KITTITAS COUNTY

DEPARTMENT OF PUBLIC WORKS

SUBJECT: LP-22-00002 Mohar Farms Preliminary Plat Comments

PRELIMINARY MOHAR FARM CLUSTER PLAT

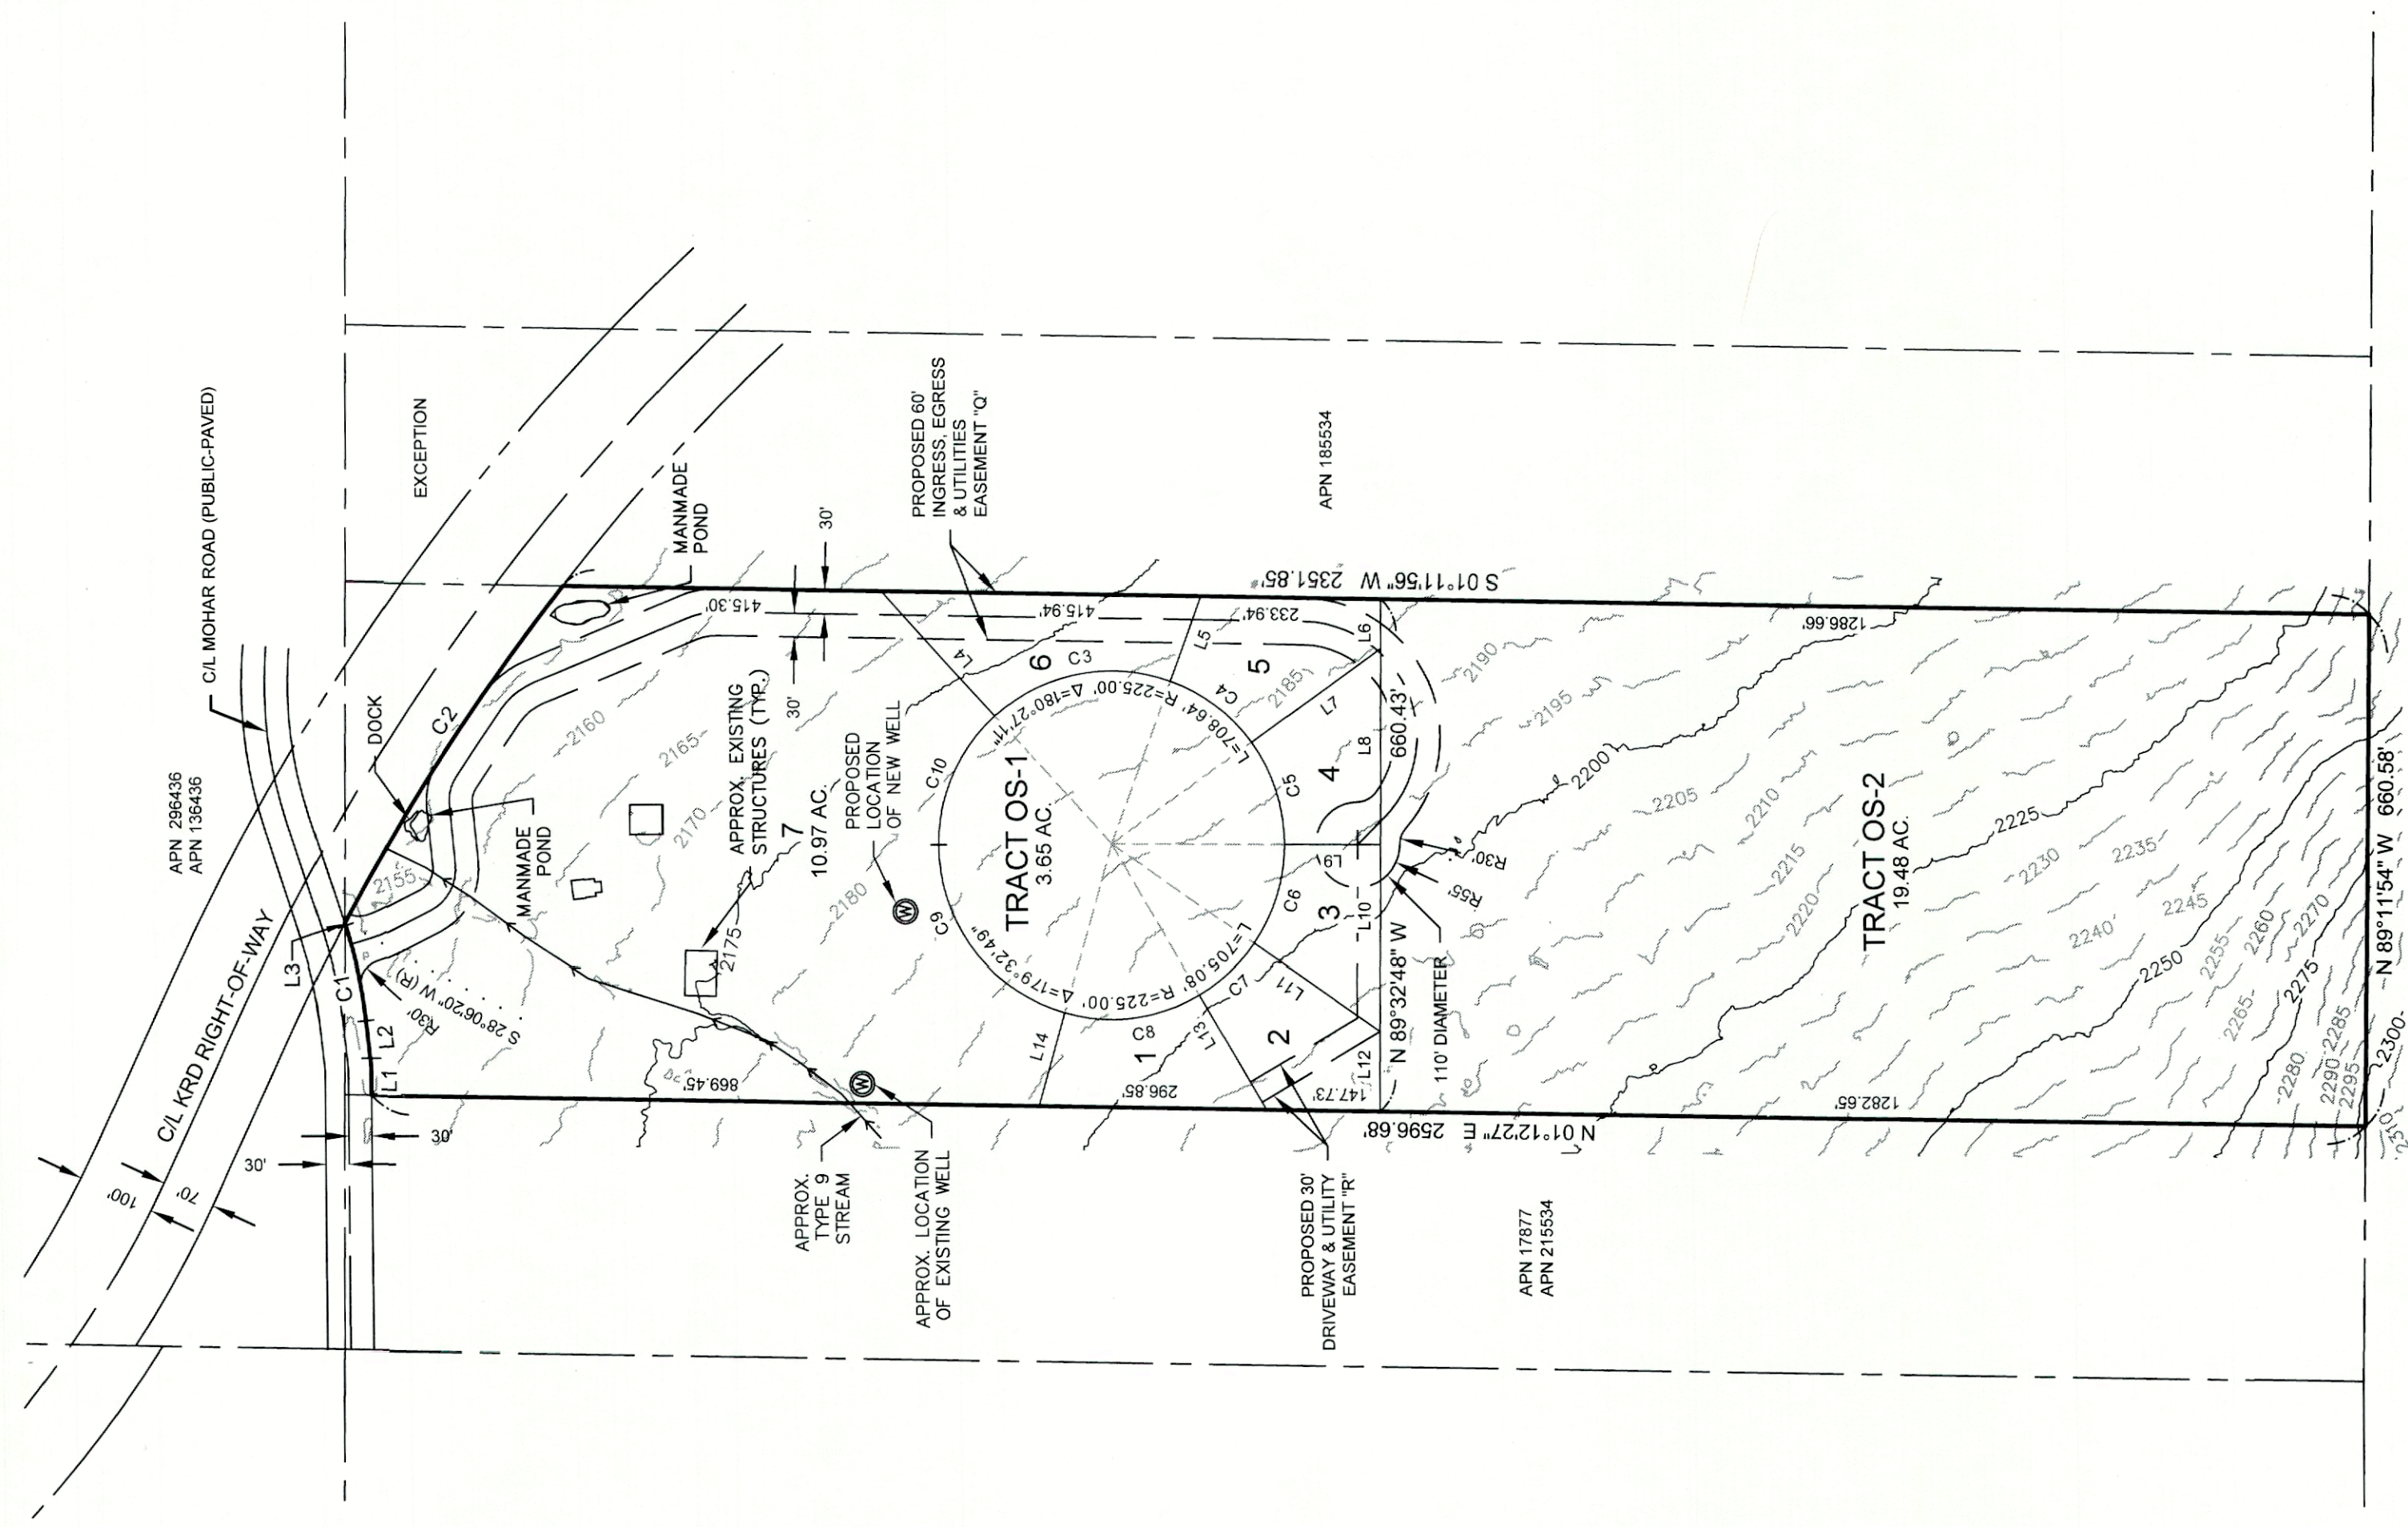
Waterway - Applicant should be aware, as more information is submitted additional permits may be needed to mitigate for the Type 9 stream shown crossing the road easement.

1. Legend will need to be on final plat
2. Basis of Bearing will need to be identified per WAC:332-130-050(1)(b)(iii)
3. Plat should have existing and proposed lot lines shown.
4. Acreage from the existing parcels to the proposed parcels does not match.
